Our Ref: BR/128/20/DOC

Approval of details reserved by condition imposed under BR/219/18/PL for condition 4-surface water drainage; 5-colour schedule of materials & finishes, 6-dustbin enclosures details; 7-electrical vehicle charging points, 8-incorporation of decentralised, renewable, low carbon energy supply system, 9-vehicular access details & 11-cycle parking space details.

9 Westloats Lane Bognor Regis PO21 5JZ

Arun District Council have decided to **REFUSE details reserved by condition for the following reasons:**

Project Proposed soakaway Plan	Sheet 4A
Date 13th May 2020	
Scale 1 : 500

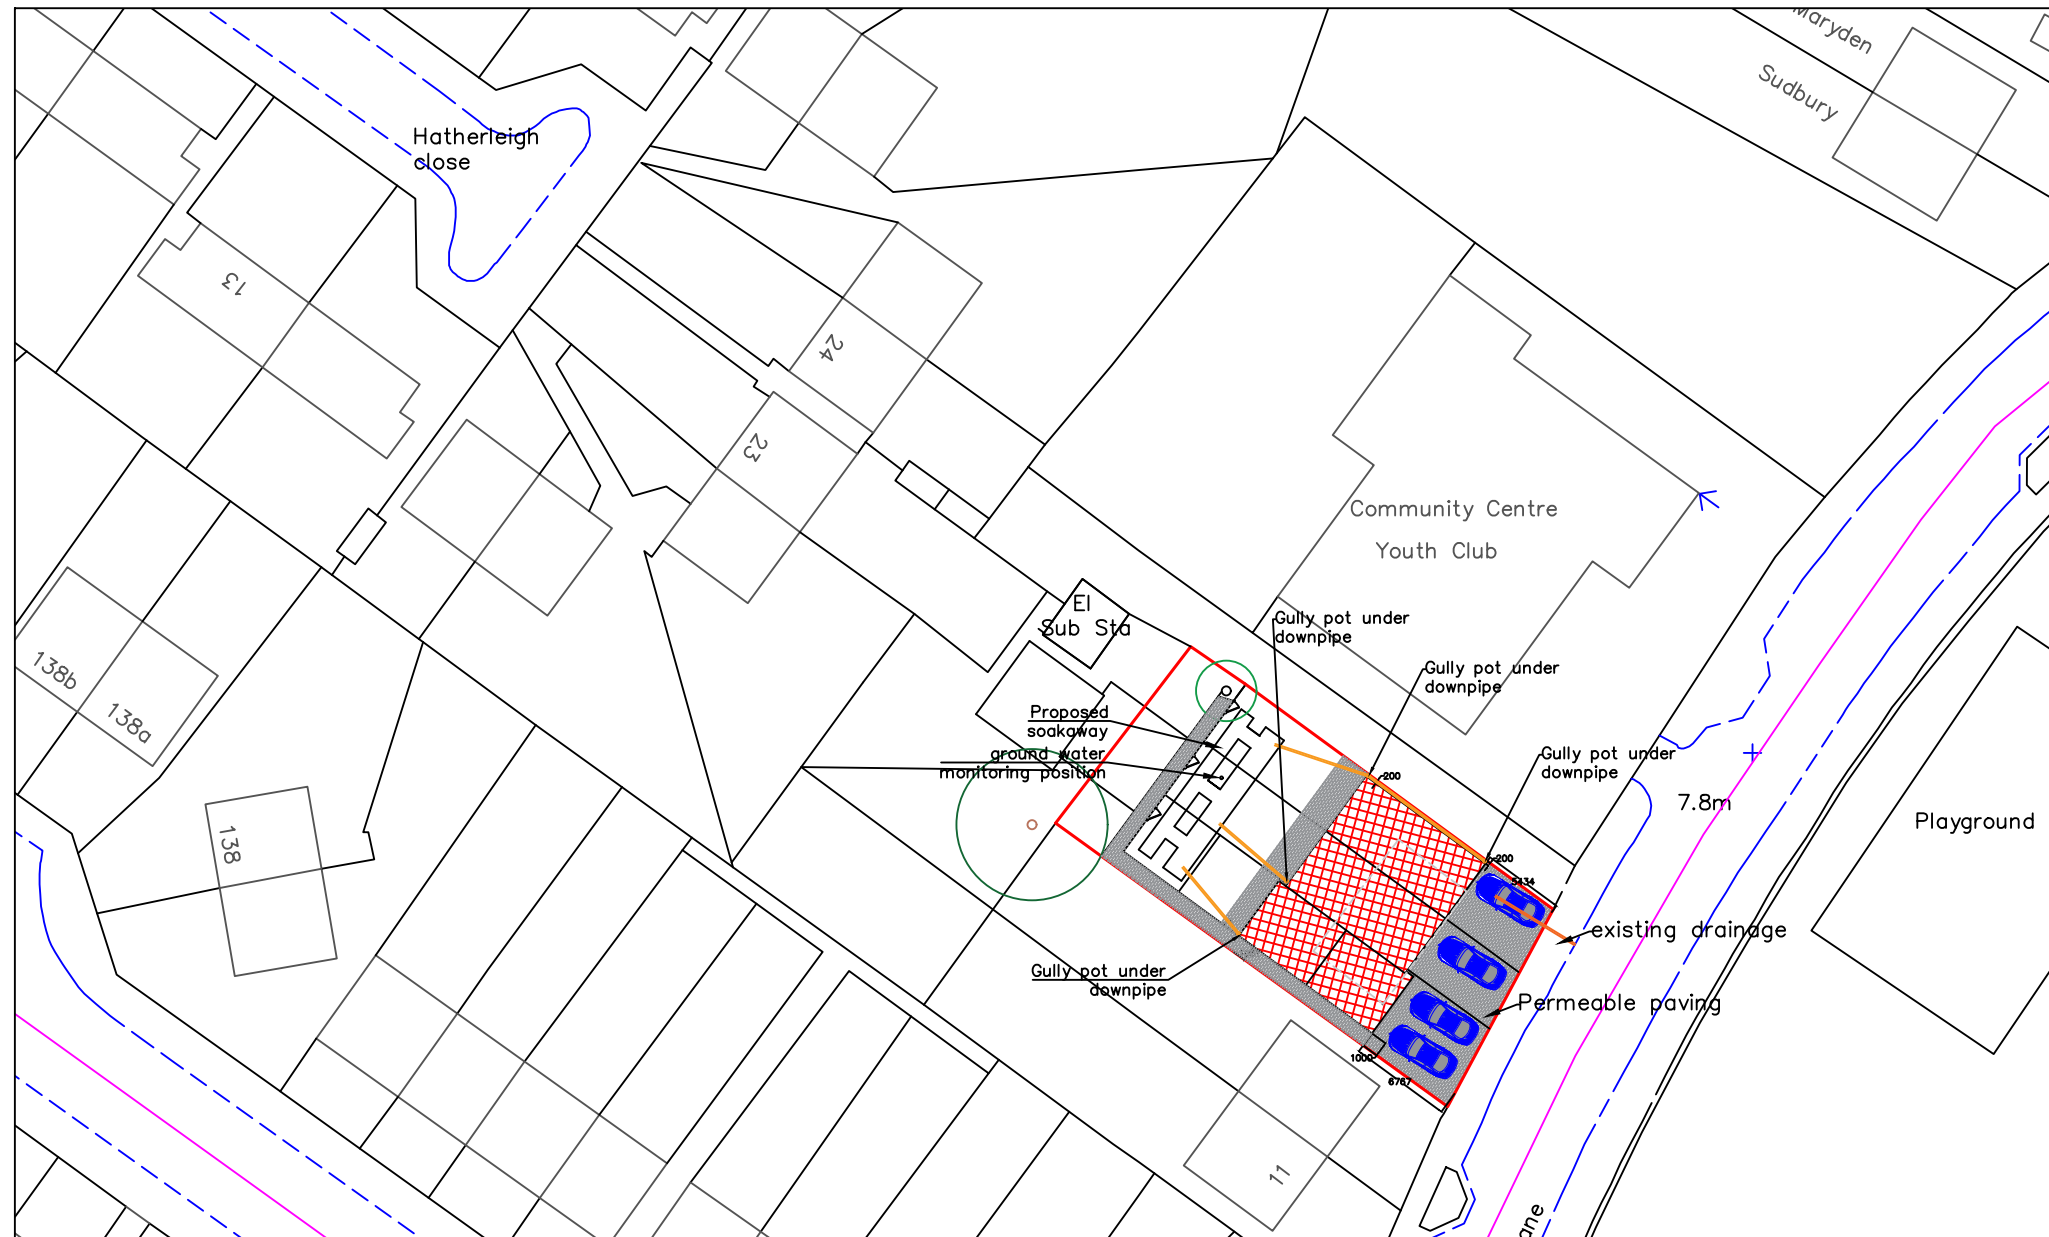
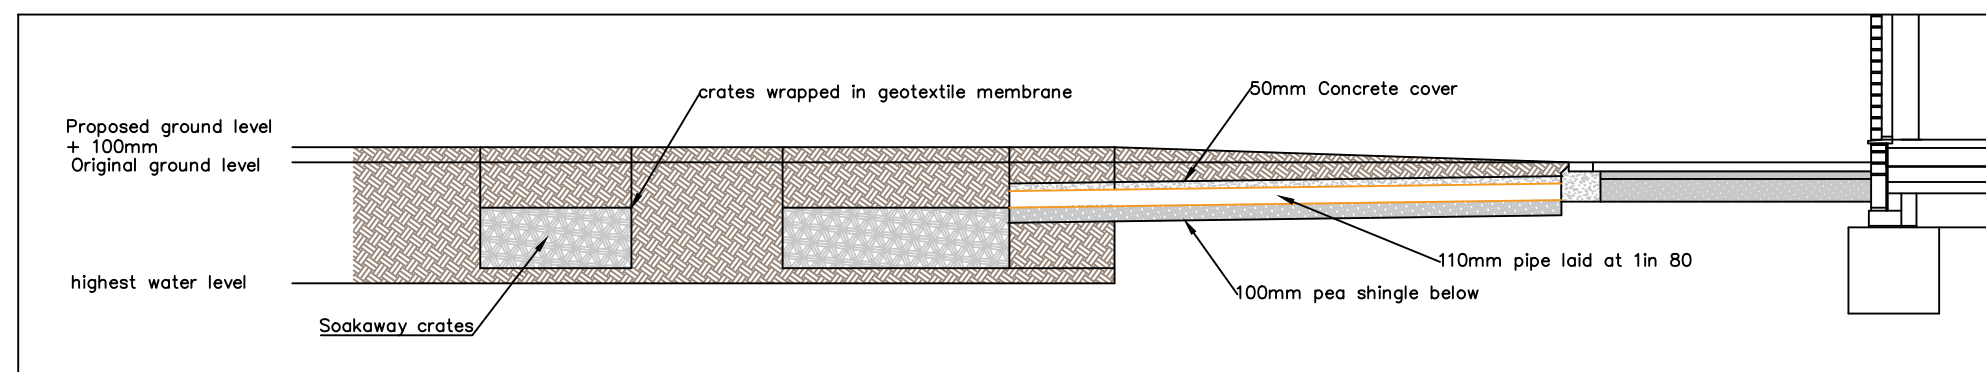
Council Drainage Engineers have objected to the discharge of this condition on the grounds that the soakaway appears to be undersized.

The soakaway sizing is appropriate for the 60 minute storm duration, however using BRE365, the applicant would need to upsize it by approximately 10m³ to cover the 24hour storm.

No calculations or dimensions have been provided for the permeable paving. At present no calculations can be run with the detail provided.
